Re: **Basement Wall Preparation Verificaiton**
Location: Lot 167 Quail Glen (Hunting Wood Dr. Angier, NC)
JDS Project No.: RDU2207939
Date of Review: 08/04/2022

JDS Consulting reviewed the previous formed wall preparation inspection and the obtained building NVR building plans (Model: Birch, set version: BRH00-01 sealed by John Chudovan, HI)

SHEET NO. A-2	MODEL BIRCH	DRAWING TITLE FOUNDATION PLAN
8	OPTION DESCRIPTION FULL BASEMENT FOUNDATION

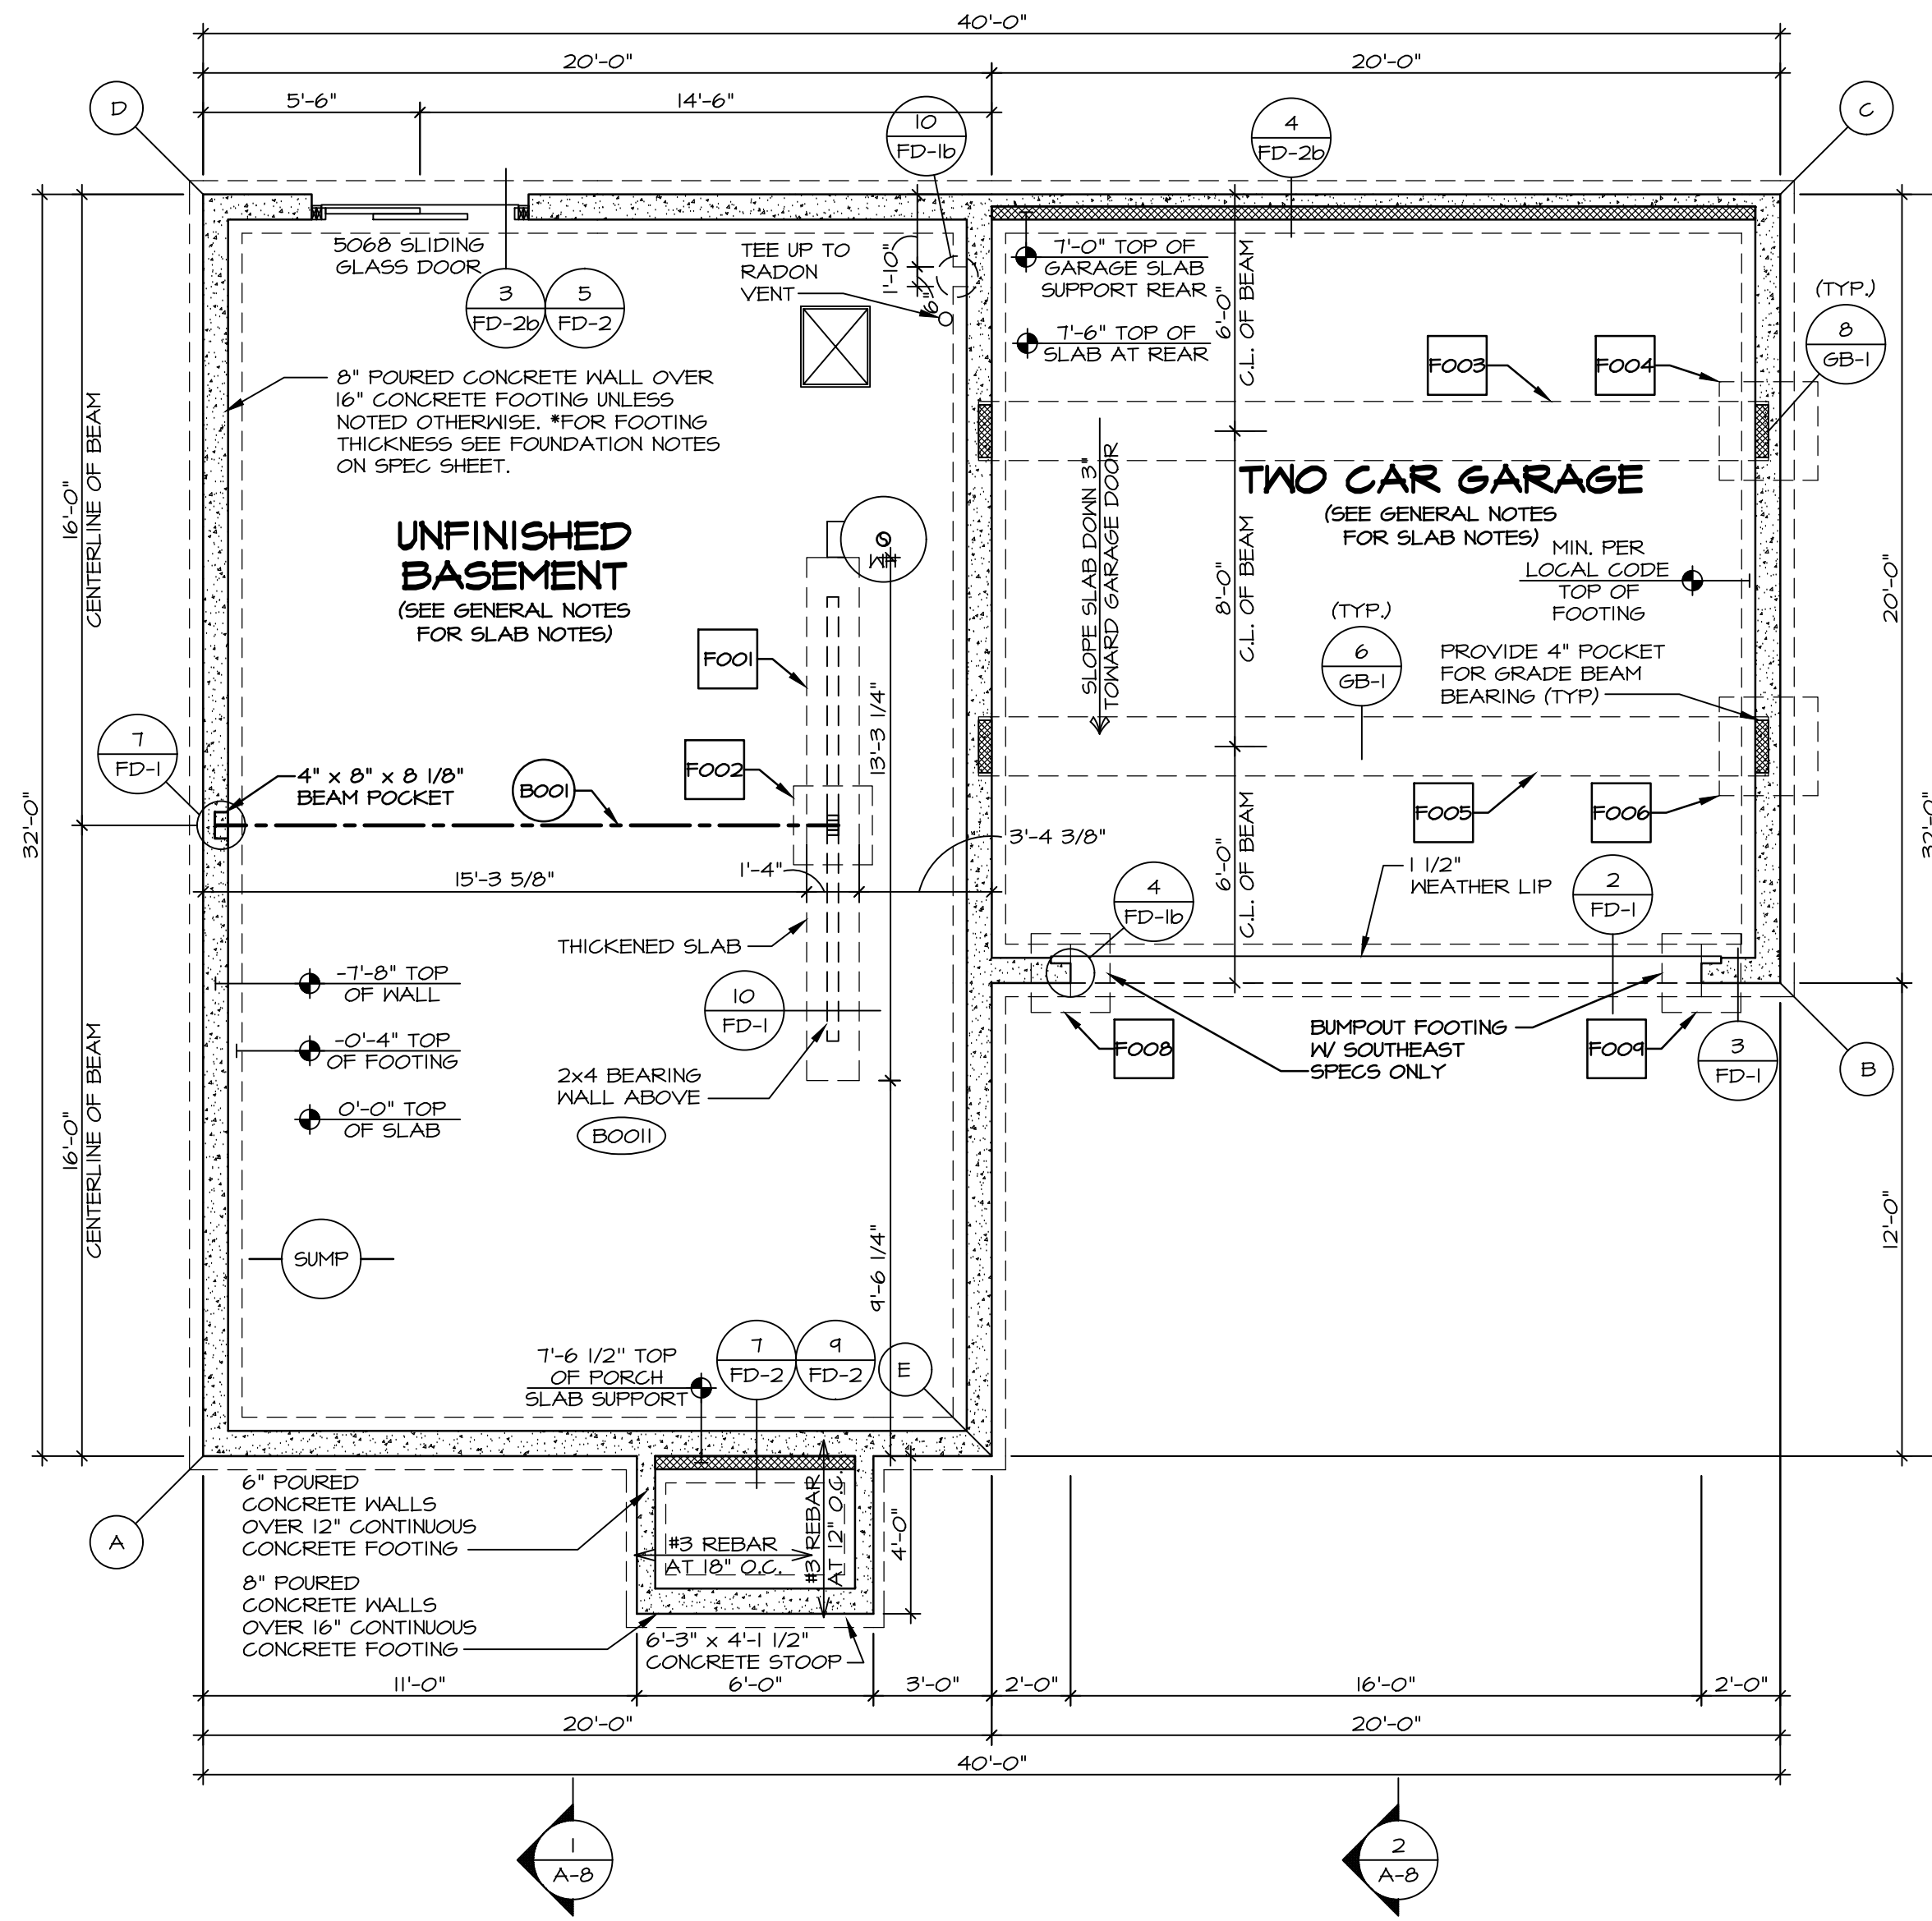
The client requested evaluation of the 8" thick CIP foundation wall at the left rear of the home that projects maximum 10'-0" from the top of the footing. Upon JDS Consulting foundation wall preparation visit RDU2206657 performed on 07/01/2022, the 10'-0" tall by 8" thick wall was reinforced with #4 rebar spaced 12" o.c. each way, biased toward the tension side of the wall.

Based on our review, the 10'-0" tall by 8" thick CIP wall is adequate for the anticipated loading conditions provided unbalanced fill does not exceed 8'6".
